Your reference      SSD 6407  
Our reference:      EF15/2643, DOC15/432054-03  
Contact:            J Goodwin 9995 6838

#### **SSD 6407 – WEST HOXTON COMMERCIAL PRECINCT EIS**

**ATTACHMENT A**  
**- ENVIRONMENT PROTECTION AUTHORITY COMMENTS -**  
**WEST HOXTON COMMERCIAL PRECINCT**

Badgerys Creek (Weather Removed From Calc): Sunday 24 May, 2015

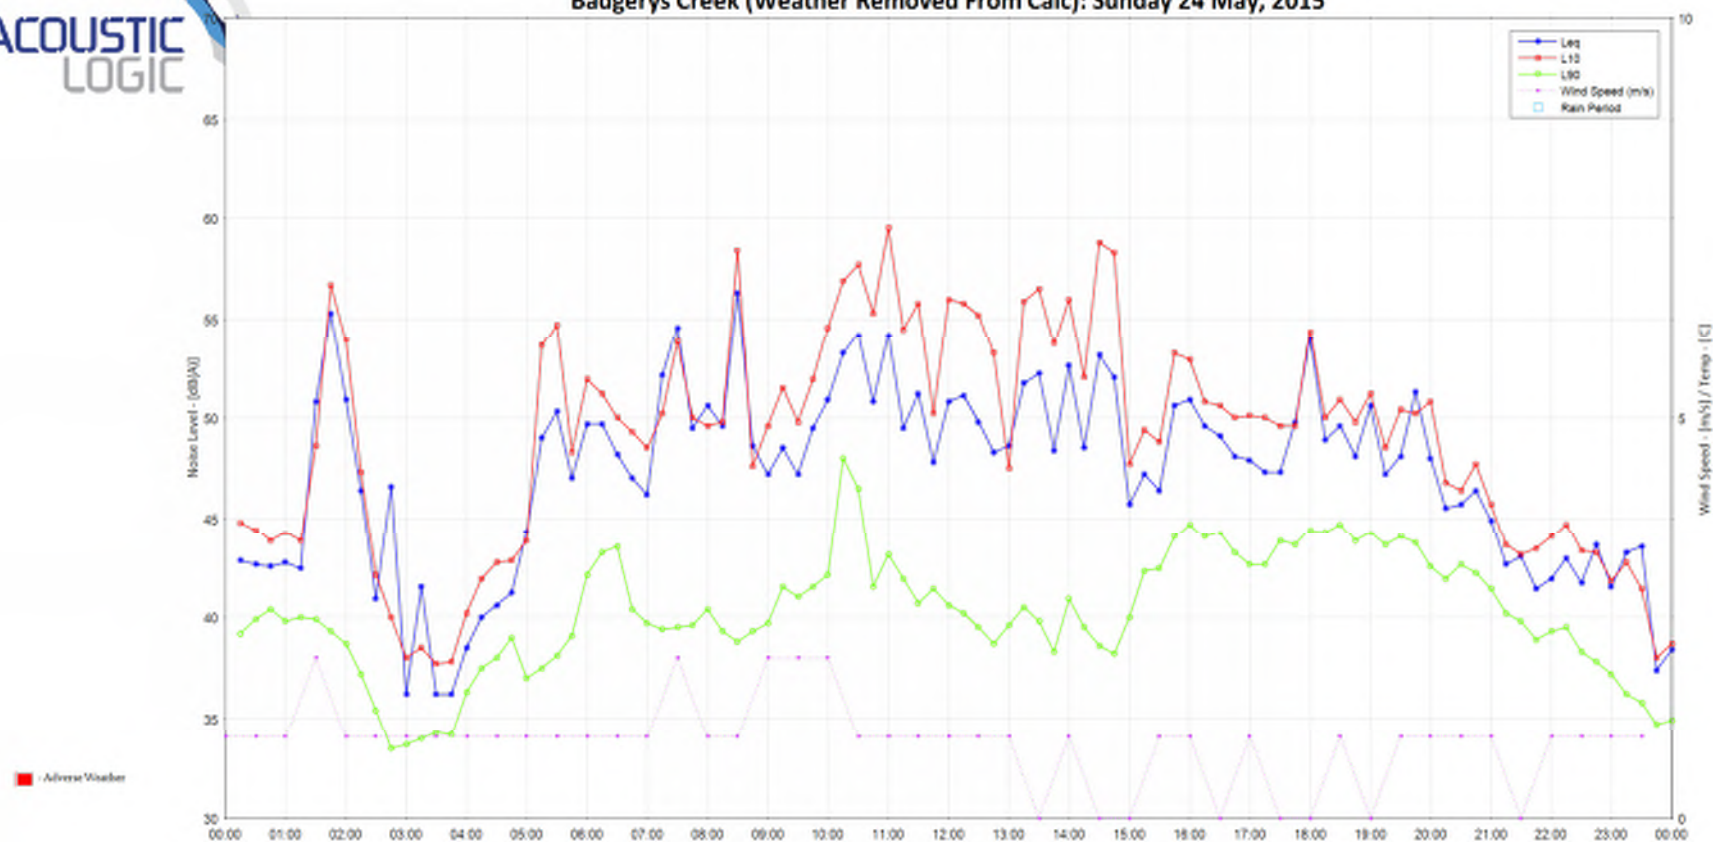
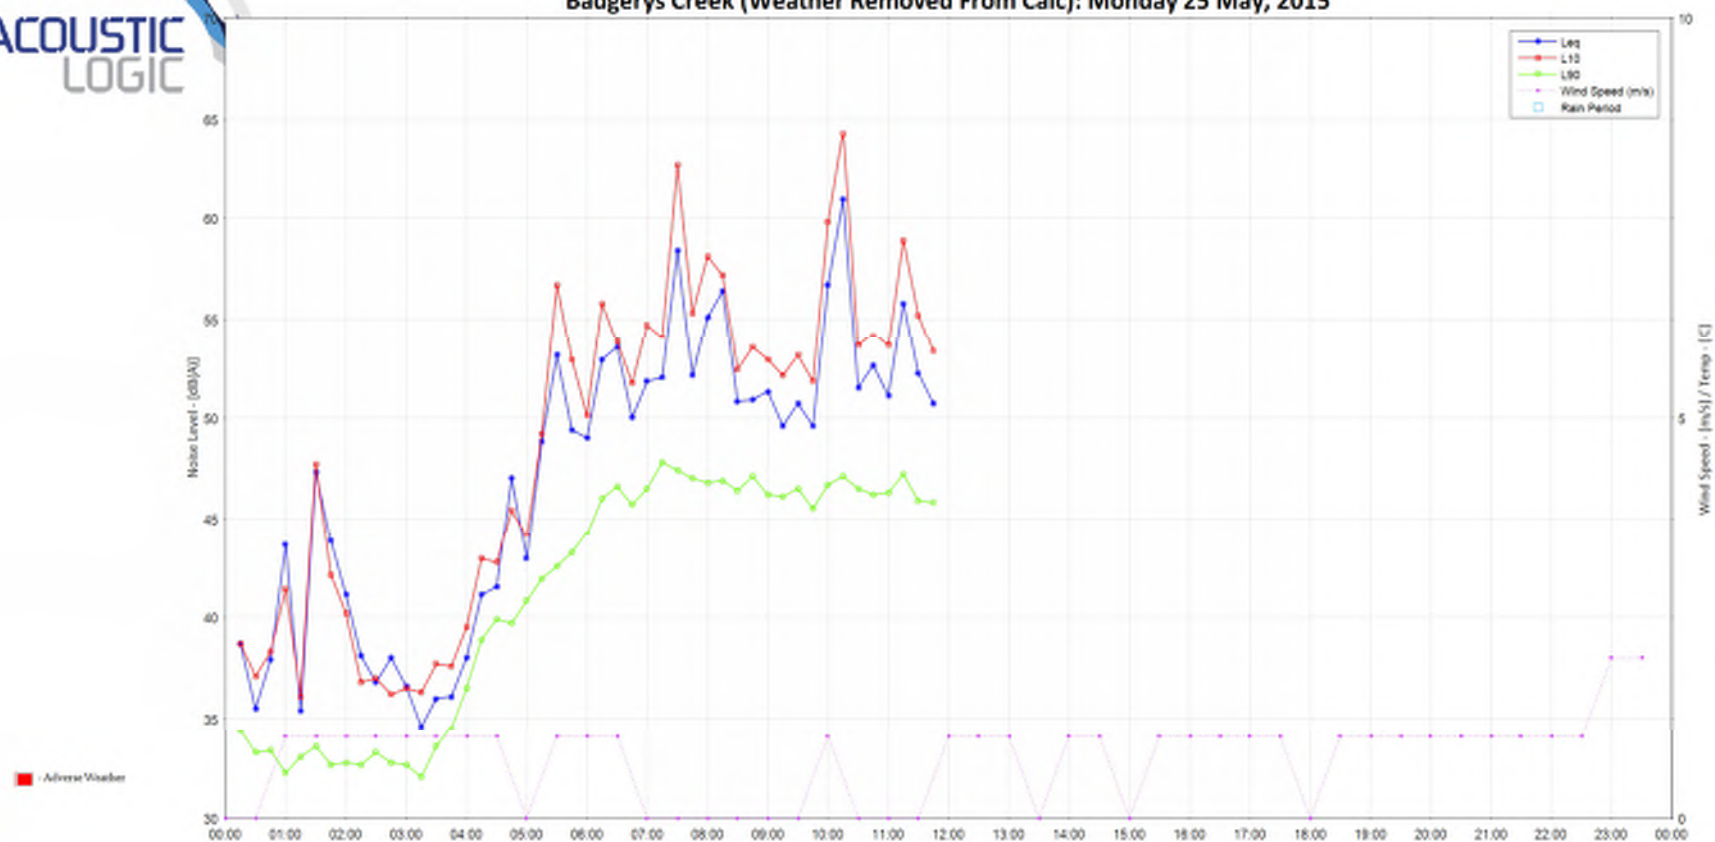
Section 4 to EIS Appendix 10 indicates that background noise monitoring was undertaken "... between 18 and 24 May 2015 ...". The Bureau of Meteorology Badgery's Creek automatic weather station indicates that-

- (a) rain was recorded each day from 19 May 2015 to 23 May 2015 inclusive,
- (b) wind gusts were recorded in excess of 18 kilometres per hour on each day from 18 May 2015 to 23 May 2015 inclusive (with gusts in excess of 18 kilometres per hour at 9:56 pm on 19 May 2015 and 12.49 am on 21 May 2015), and
- (c) wind speeds in excess of 18 kilometres per hour were recorded at 9.00 am and 3.00 pm on 22 May 2015 and again at 9.00 am on the following day.

Accordingly, the EPA considers that some of the noise monitoring data obtained between 18 and 24 May 2015 should be excluded for the purposes of establishing background noise levels, which would result in there being less than the 7 days of valid monitoring recommended in the NSW Industrial Noise Policy (INP). Thus, the proponent should undertake further noise monitoring to obtain not less than 7 days of valid noise monitoring data as the basis for establishing background noise levels (especially night-time levels) in the locality. Alternatively, the proponent may adopt a night-time background noise level of 30 dBA.

The proponent be required to adopt a night-time background level of 30 dBA or undertake further noise monitoring to obtain 7 days of valid data under acceptable meteorological conditions, (as described in section 3.4 of the NSW Industrial Noise Policy) for the purpose of –

- (a) revising the evening and night-time background noise levels in the locality, and
- (b) re-assessing predicted noise impacts.
